HERTFORDSHIRE HOST AUTHORITIES' RESPONSES TO THE APPLICANT'S RESPONSES TO WRITTEN REPRESENTATIONS

London Luton Airport Expansion

DATE: 5 OCTOBER 2023

Figure 3.4: Indicative locations of survey cameras associated with MT1

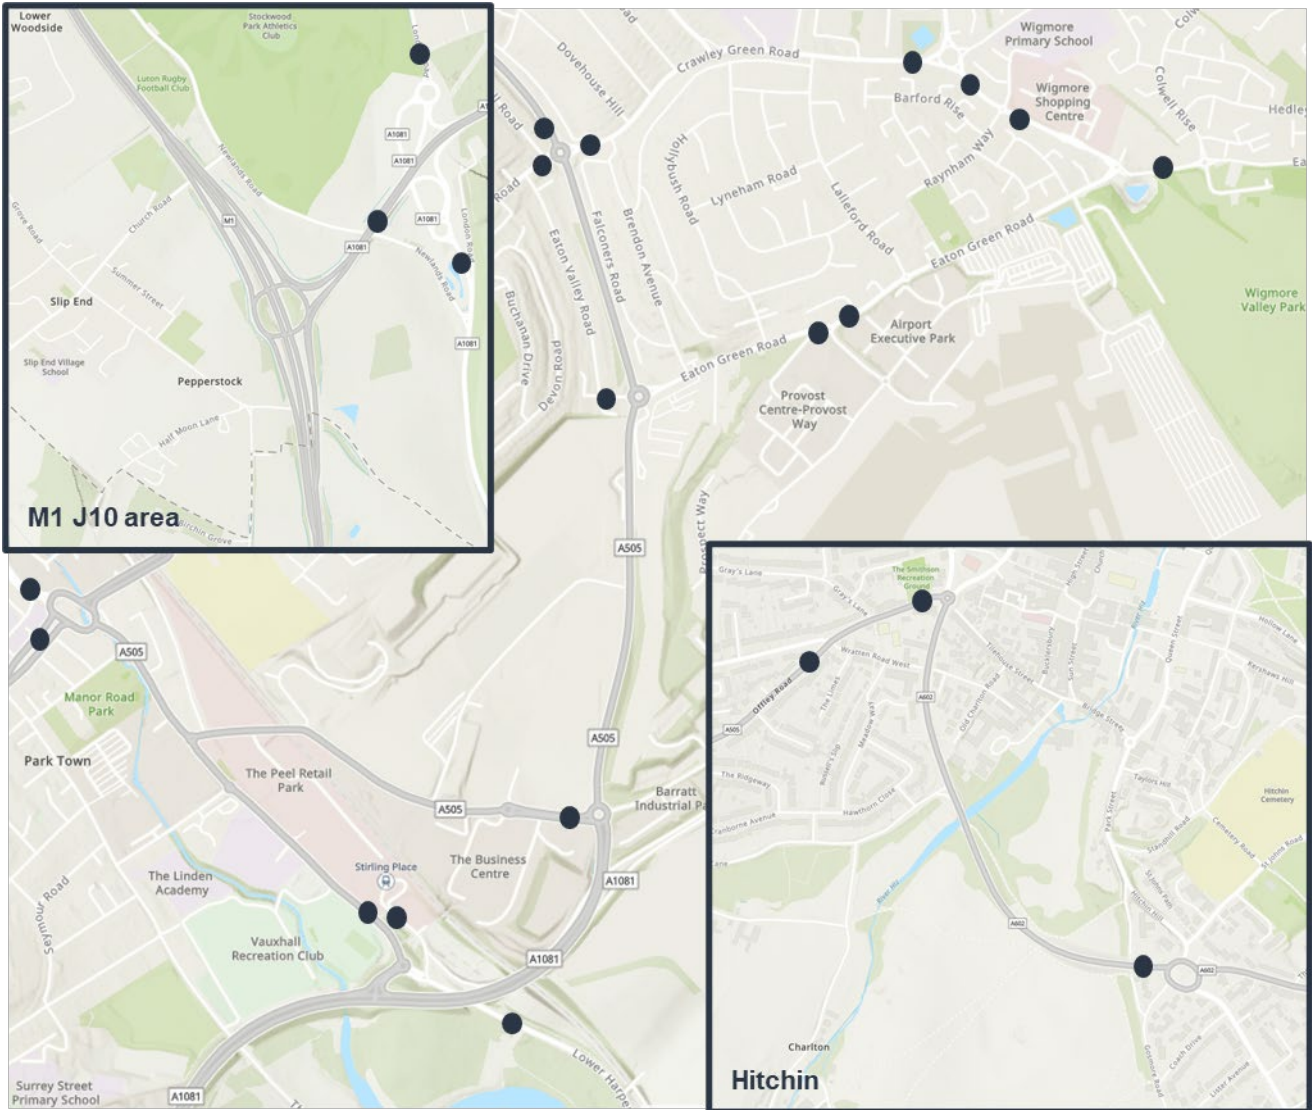
Ref.	Topic	Matters Raised in Written Representation	Applicant's Response	HAs' Response
		vehicles between the airport and agreed locations in North Hertfordshire using linked ANPR cameras.		<p>7) The currently proposed locations for ANPR cameras will not identify or quantify traffic passing through villages around Luton, as it will only capture that traffic once it is close to the airport (and mixed with local traffic). For reference, TA paragraph 15.2.1 states, "Work with the local highway authorities to monitor and consider the need for traffic management measures to address airport related impacts in residential or rural areas including Great Offley, Tea Green, Breachwood Green and Whitwell." (N.B. the list of villages cited as potentially being impacted is not comprehensive.)</p>
